DECISION DELEGATED TO HEAD OF PLANNING

Application No: H22-0532-25 **Applicant:** Mr J Snell & Ms M Daw
Proposal: Proposed single storey extension to house
Location: 163 Broadgate Weston Hills Spalding
Terminal Date: 25th July 2025

Drawing Title:
**Ground floor plan, elevations and roof plan
as proposed**

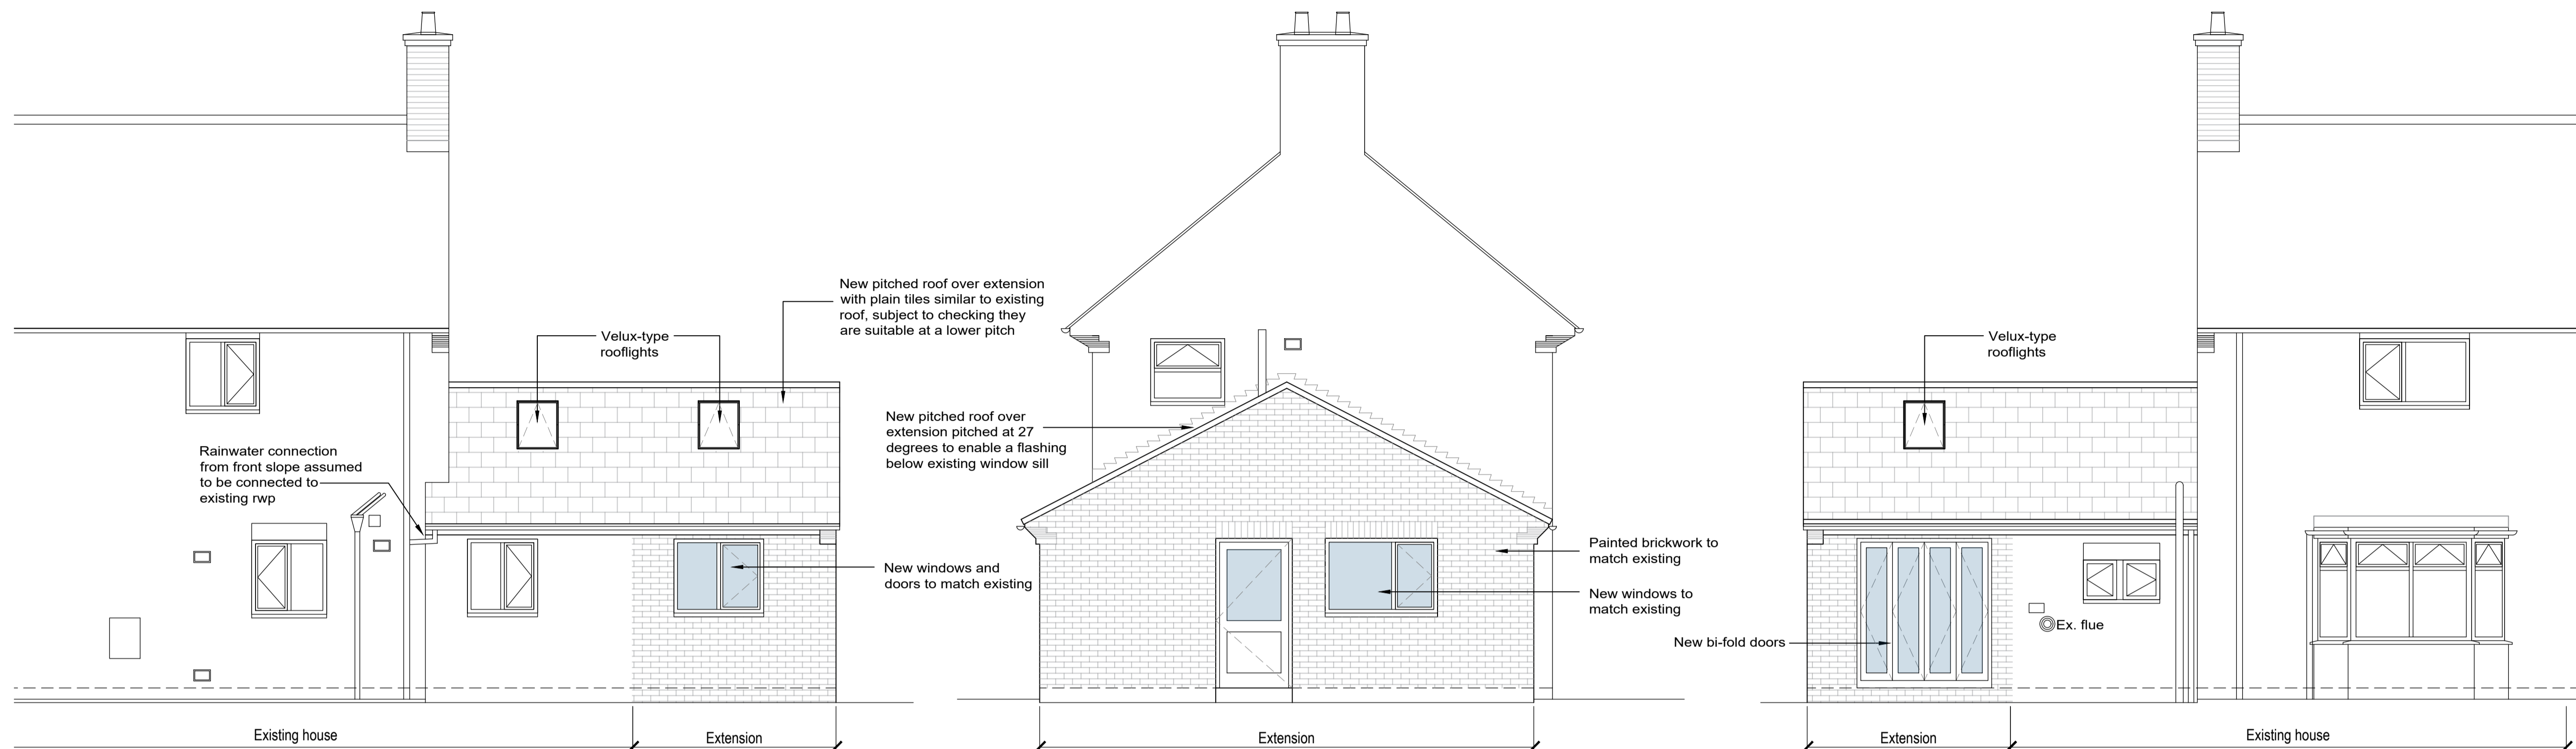
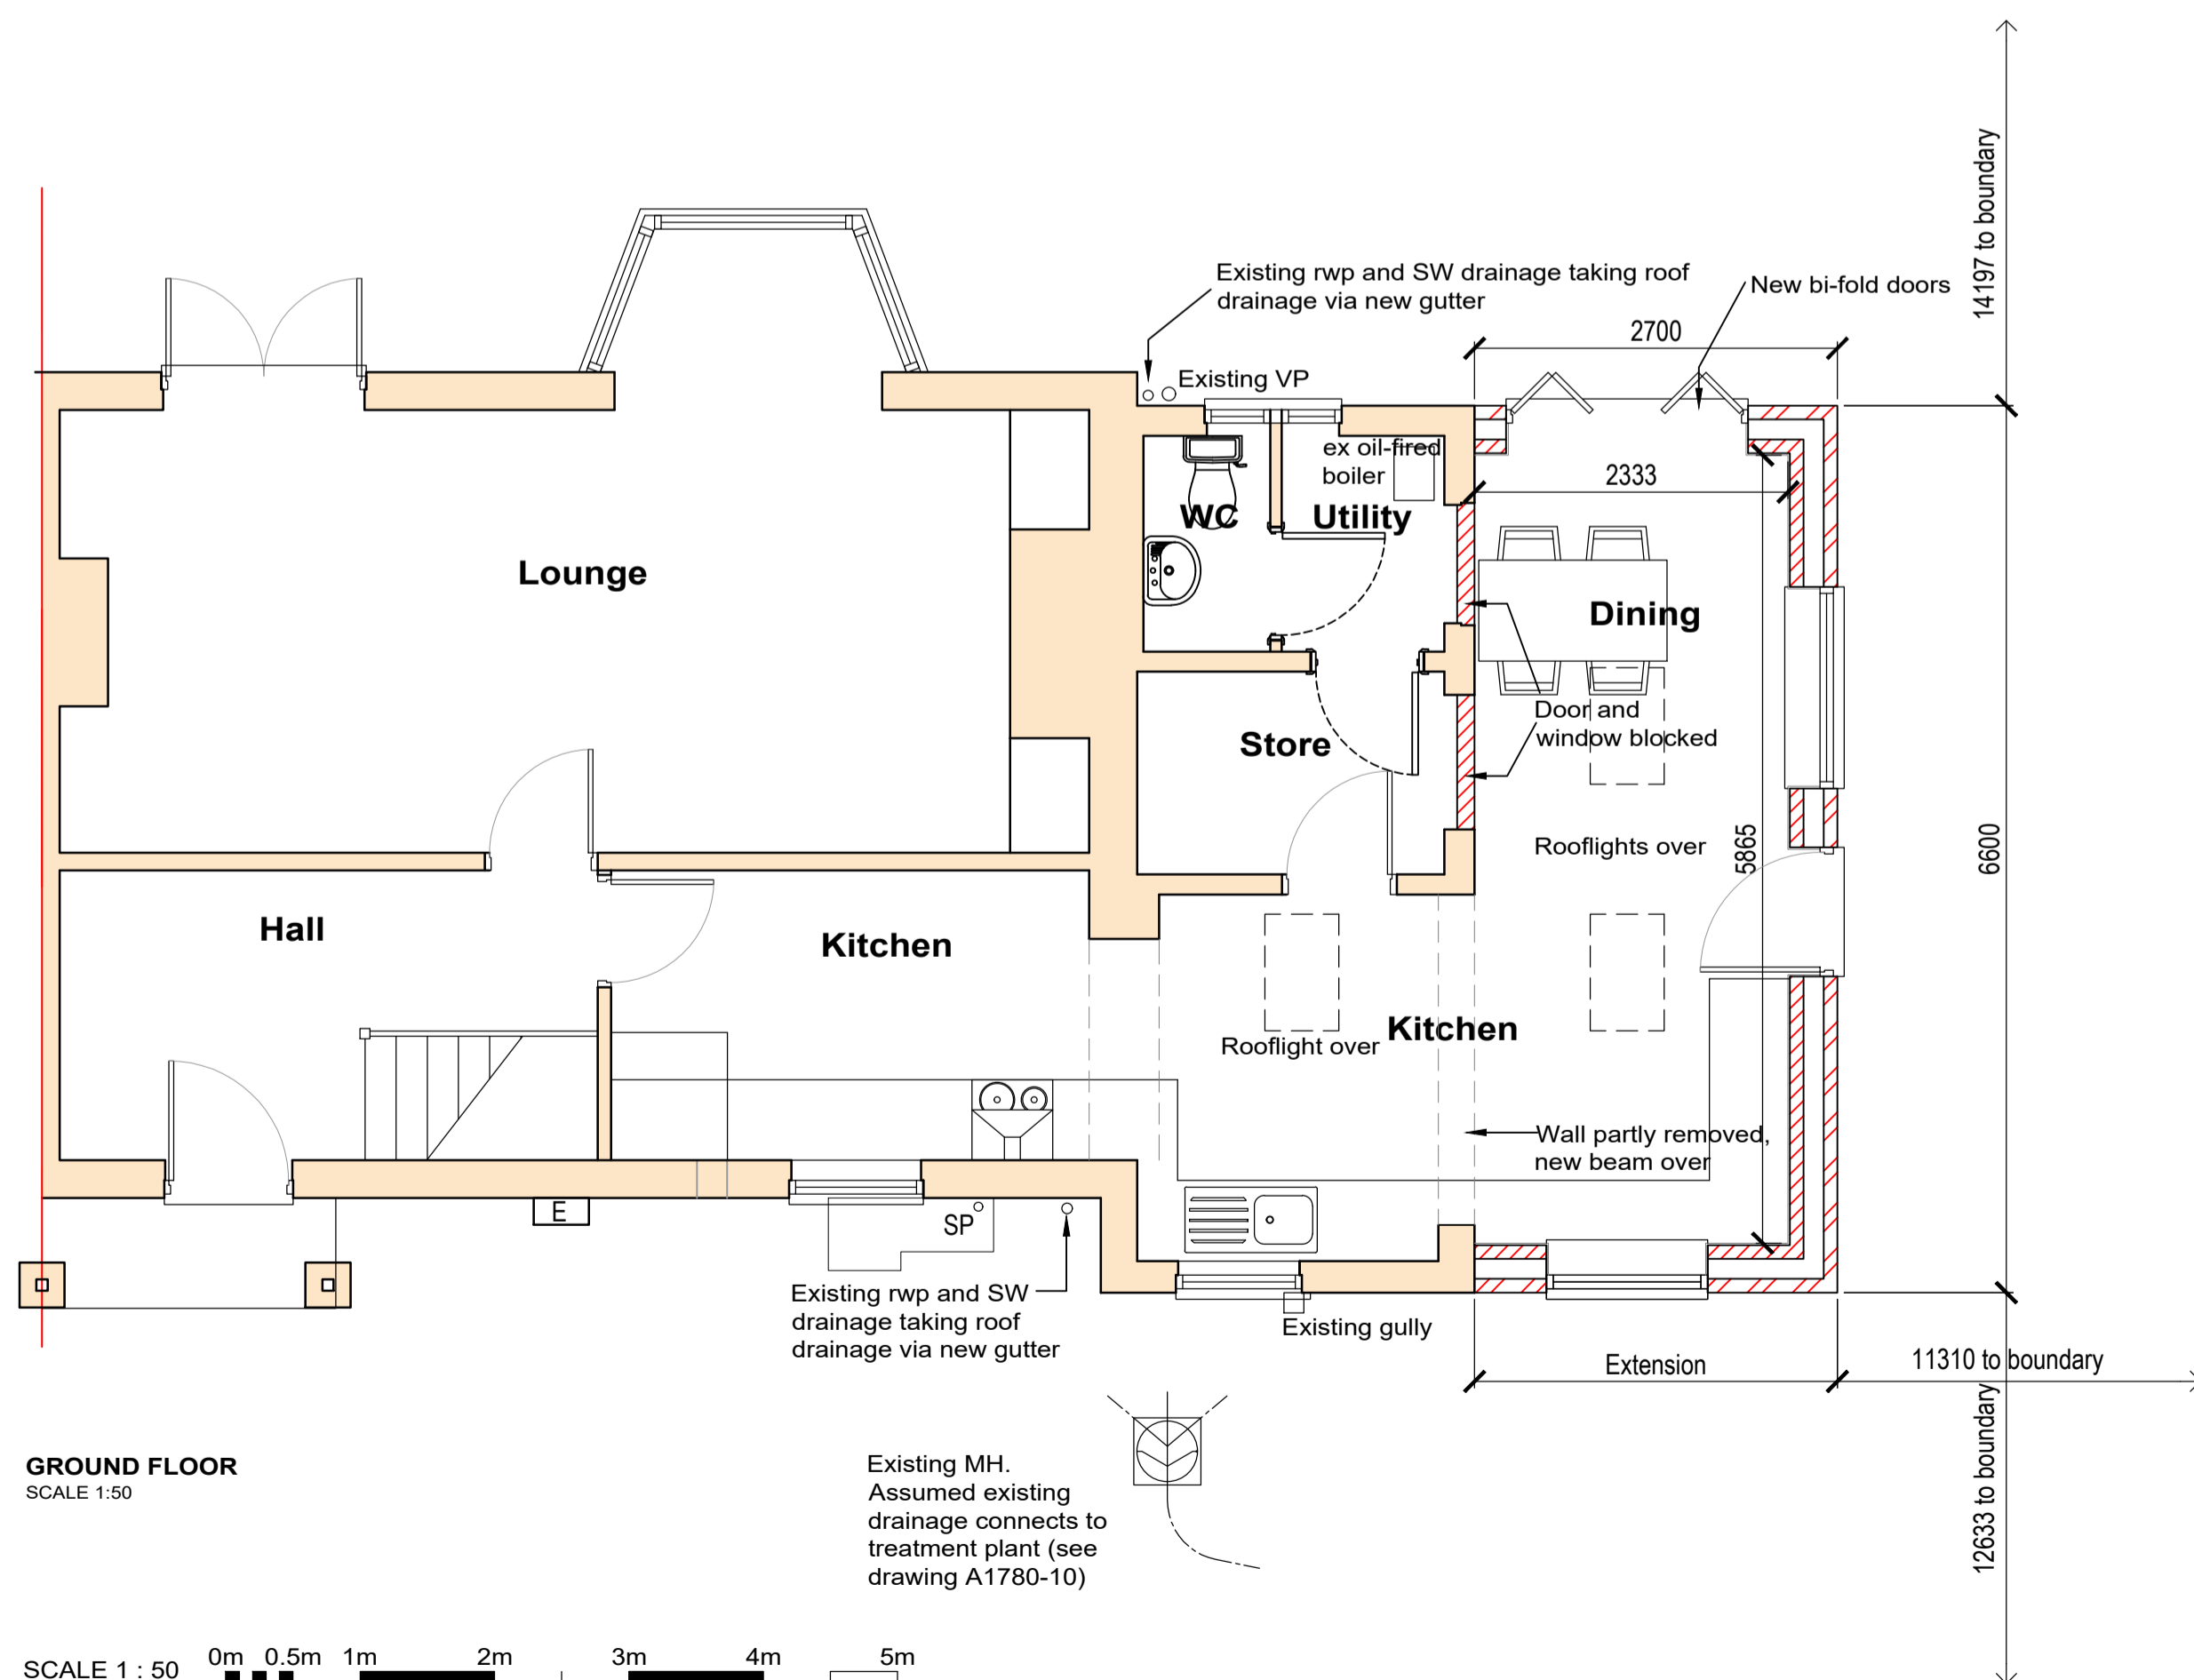
The existing dwelling comprises a semi-detached two storey dwelling, located to the east of Broadgate. The extension would be located on the southern side elevation. The extension is proposed to measure 2.7m by 6.6m, however, the built form would largely be located over the footprint of the existing side extension. The current extension features a flat roof, whereas the proposed extension would feature a gable end roof form. Given that the main dwelling features a gable end roof form, the revised roof is considered to be more suitable. The scale and siting of the extension is acceptable as it would be subservient to the main dwelling.

Two velux rooflights are proposed on the front roof slope, and one rooflight is proposed on the rear roof slope. The positioning of the rooflights, windows and doors on the extension is considered to be suitable.

It is proposed for the extension to feature painted brickwork to match the main dwelling. Plain roof tiles to match the main dwelling are also proposed. The visual impact of the proposed development is therefore acceptable. The proposed development would not cause an adverse impact to the character or appearance of the area and would therefore accord with Policies 2 and 3 of the Local Plan and Section 12 of the NPPF.
